This is to certify that WESCOTT & PAYSON II / Westcott
has permission to 24 x 36 Colonial w/ 18.5 x 2 garage
AT 140 YALE ST (Lot 10) 438 A020001

City of Portland, Maine - Building or Use Permit Application

ONE AND TWO FAMILY	PLAN REVIEW	CHECKLIST
Soil type/Presumptive Load Value (Table R401.4.1)	Submitted Plan	Findings/Revisions/Dates
STRUCTURAL		
Footing Dimensions/Depth (Table R403.1 & R403.1(1), (Section R403.1 & R403.1.4.1))	10" x 16" - OK	
Foundation Drainage, Fabric, Damp proofing (Section R405 & R406)	Damage not labeled & size	- OK
Ventilation/Access (Section R408.1 & R408.3) Crawls Space ONLY	N/A	
Anchor Bolts/Straps, spacing (Section R403.1.6)	Size of bolt	- OK
Lally Column Type (Section R407)		
Girder & Header Spans (Table R 502.5(2)) Built-Up Wood Center Girder Dimension/Type	Need to show where point loads from cills are carried	
Sill/Band Joist Type & Dimensions First Floor Joist Species Dimensions and Spacing (Table R502.3.1(1) & Table R502.3.1(2))	OK	
Second Floor Joist Species Dimensions and Spacing (Table R502.3.1(1) & Table R502.3.1(2))	2x10 - 16" oc	OK
Attic or additional Floor Joist Species Dimensions and Spacing (Table R802.4(1) and	2x8 - 16" oc	/

CHECK-LIST

SECTION @ PORCH

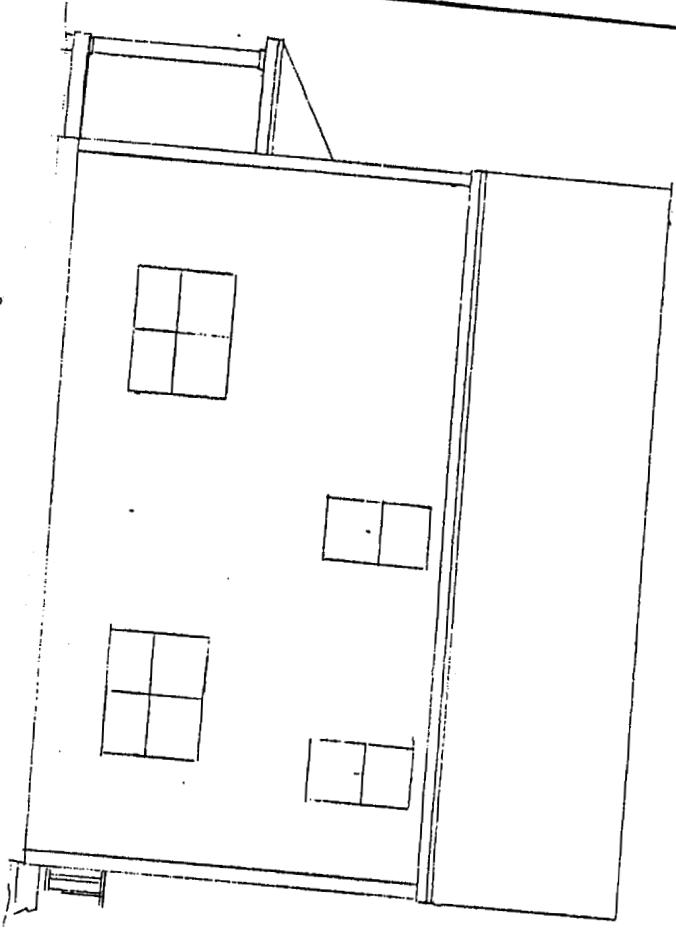
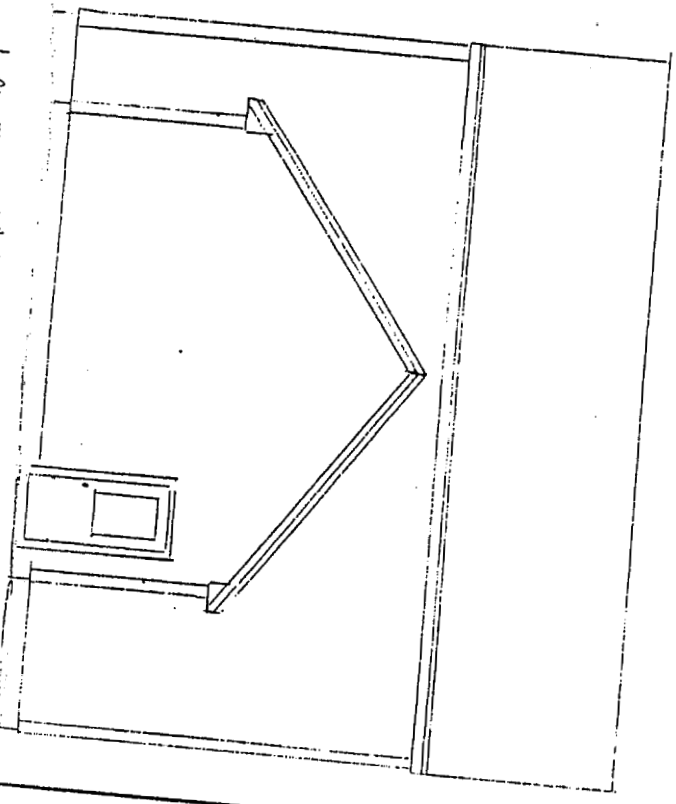
Type of Heating System	Fireplace	Chimney / direct vent	
Means of Egress (Sec R311 & R312)			
Basement	2		
Number of Stairways	2		
Interior	2		
Exterior	0		
Treads and Risers (Section R311.5.3)	10" T / 7 3/4" R		
Width (Section R311.5.1)	3'-0" +		
Headroom (Section R311.5.2)	6'-8"		
Guardrails and Handrails (Section R312 & R311.5.6 - R311.5.6.3)	OK	See elevation	
Smoke Detectors (Section R313) Location and type/Interconnected		Not shown	
Dwelling Unit Separation (Section R317) and IBC - 2003 (Section 1207)		N/A	
Deck Construction (Section R502.2.1)		Front - need header +	Roost protection + deck framing

Beam - need 4" Piers + Girder size for deck + ledger details.

| Foundation Plan | |

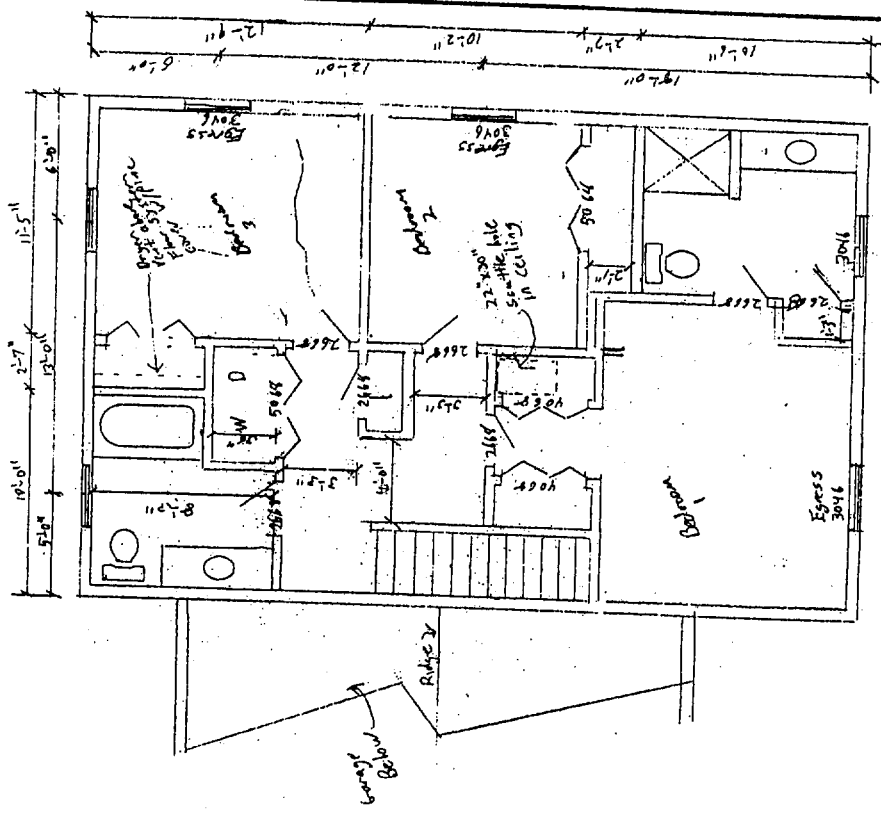
- 1) The basement is NOT approved as habitable space.
- 2) The owner and builder agree to submit a statement from a licensed surveyor PRIOR to placement of backfill stating the location of the structure is compliant with the City of Portland required setbacks.
- 3) Separate permits are required for any electrical, plumbing, or heating.
- 4) Permit approved based on the plans submitted and reviewed w/owner/contractor, with additional information as agreed on and as noted on plans.
- 5) As discussed, hardwired interconnected battery backup smoke detectors shall be installed in all bedrooms, protecting the bedrooms, and on every level.
- 6) As discussed, reviewed and noted on the plans, the maximum span of 3-2"x12"s is 6'-6".

TITLE:
YALE STREET, LOT #10

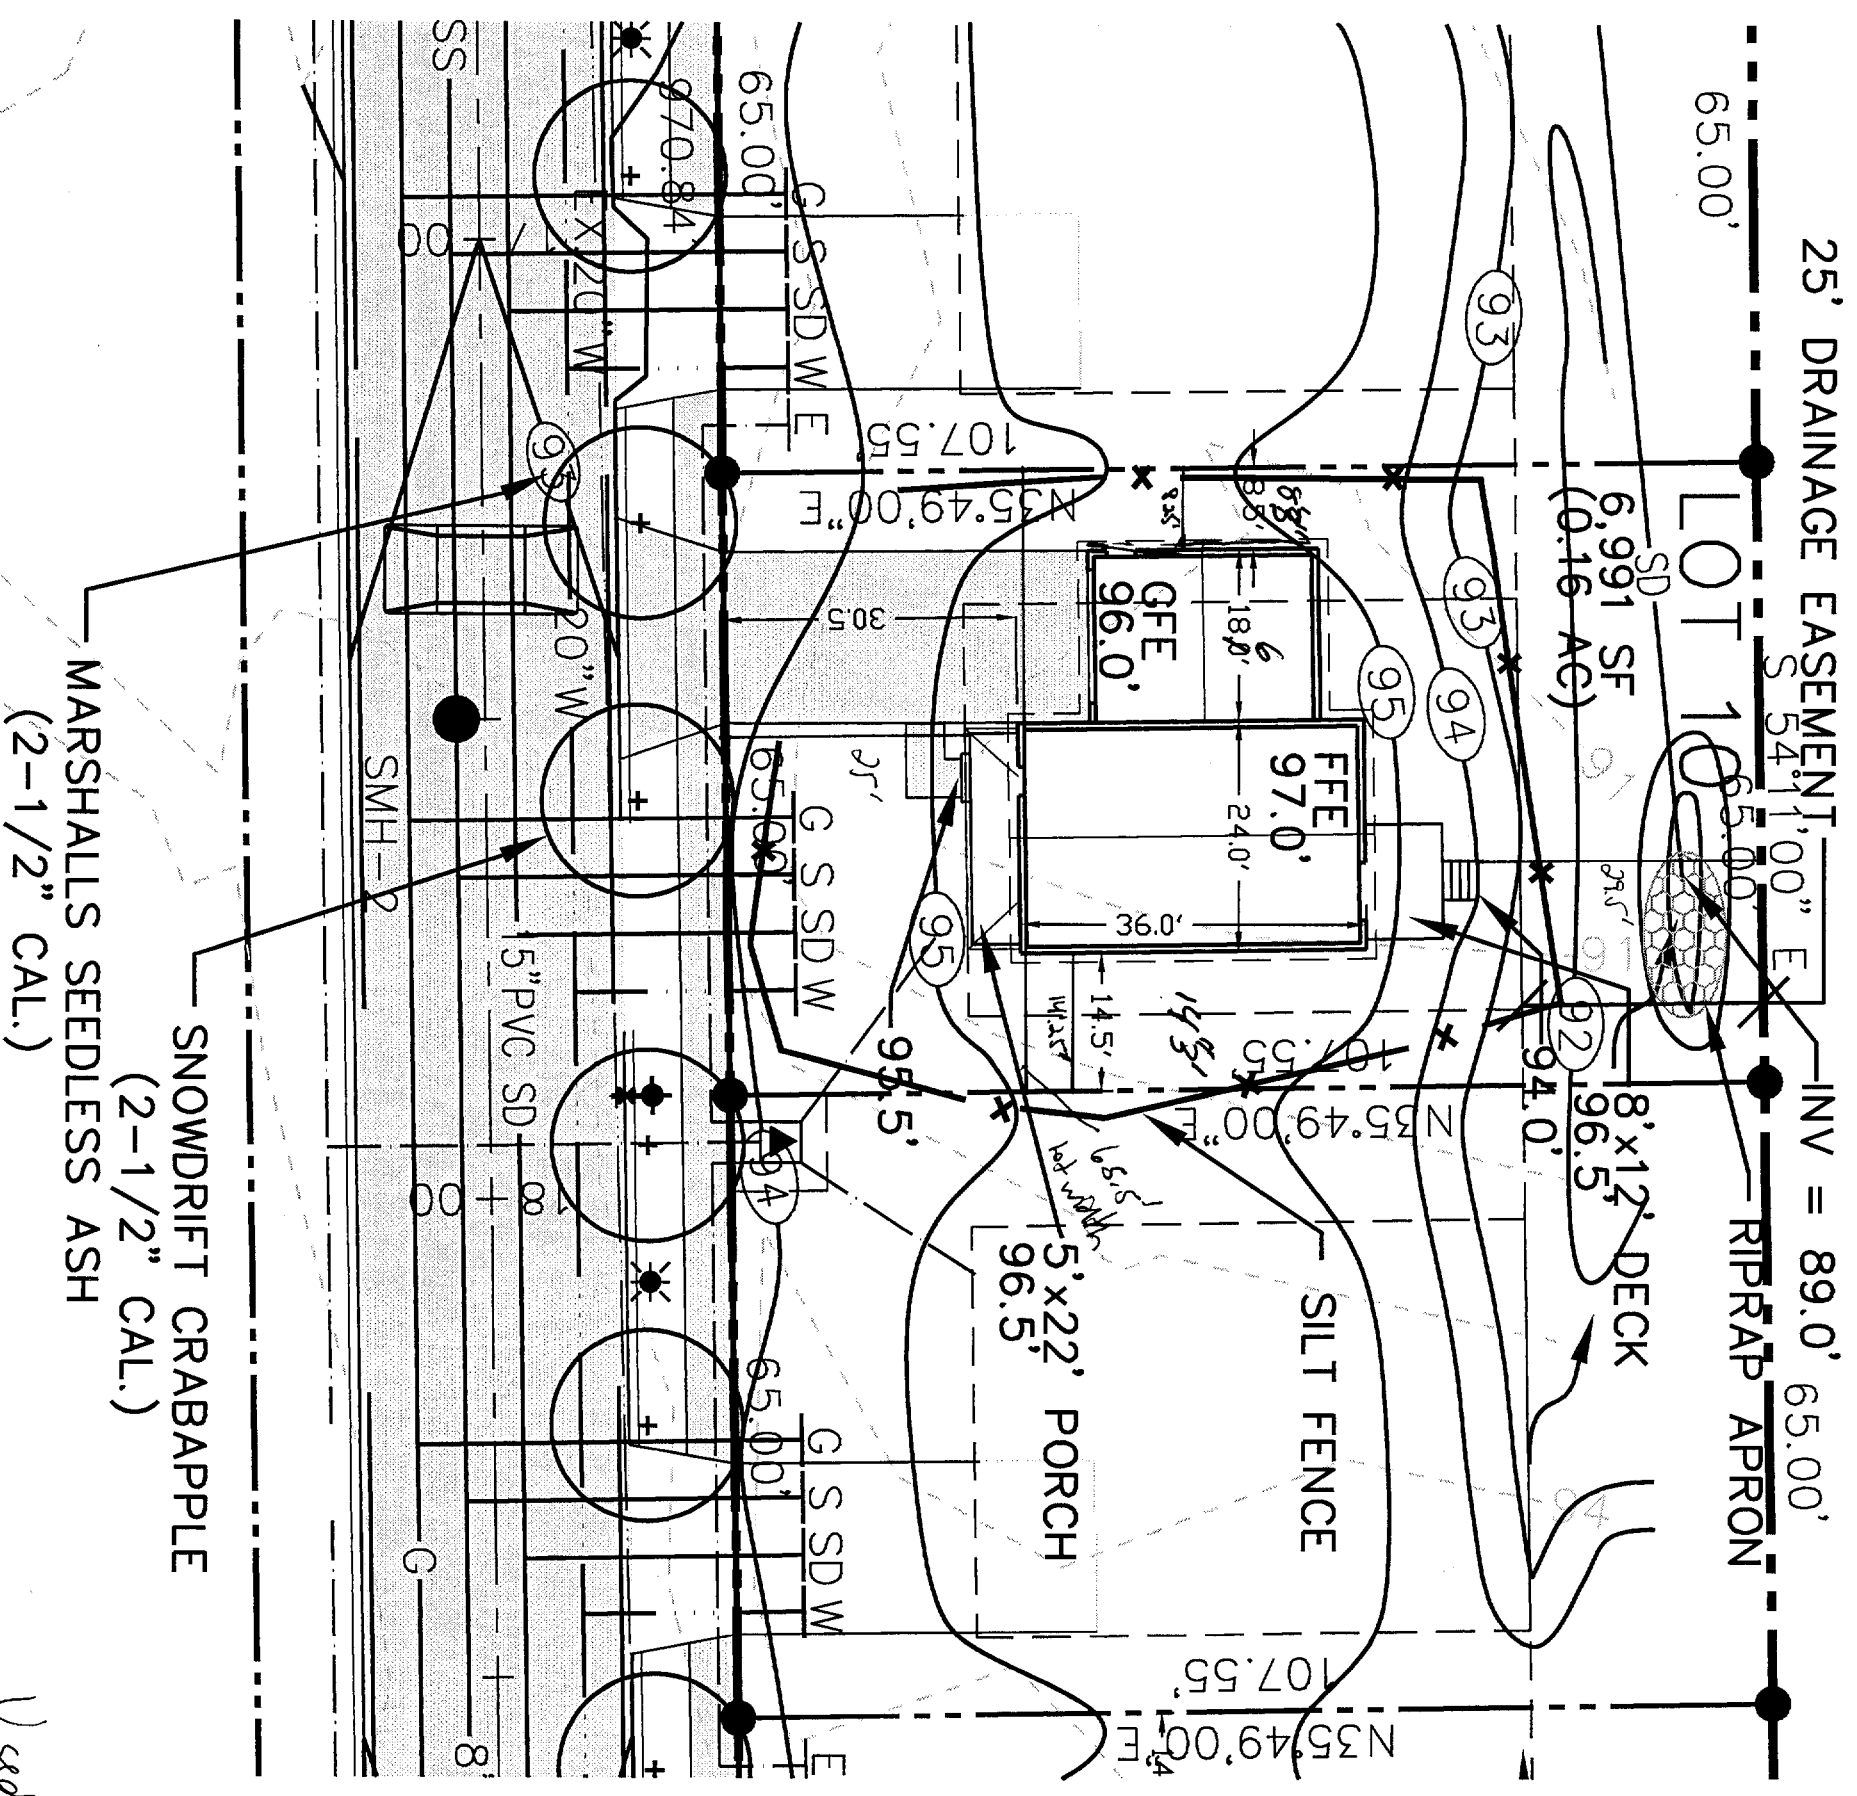
Front Yard - 25' min - 25' scaled from front porch

Rear Yard - 25' min - 29.5' scaled from deck steps

Side Yard - 1 1/2 sky 8' - 8.25' on left (scaled) from garage.
2 sky 14' - 14.25' on right - scaled from house.

Projections - 5' x 22' porch, 1 x 5' step, 8 x 12 deck, 4 x 3.5' steps

Height - 35' max - 24.75' scaled

Lot Area - 6,500 sq ft min - 6,991 sq ft
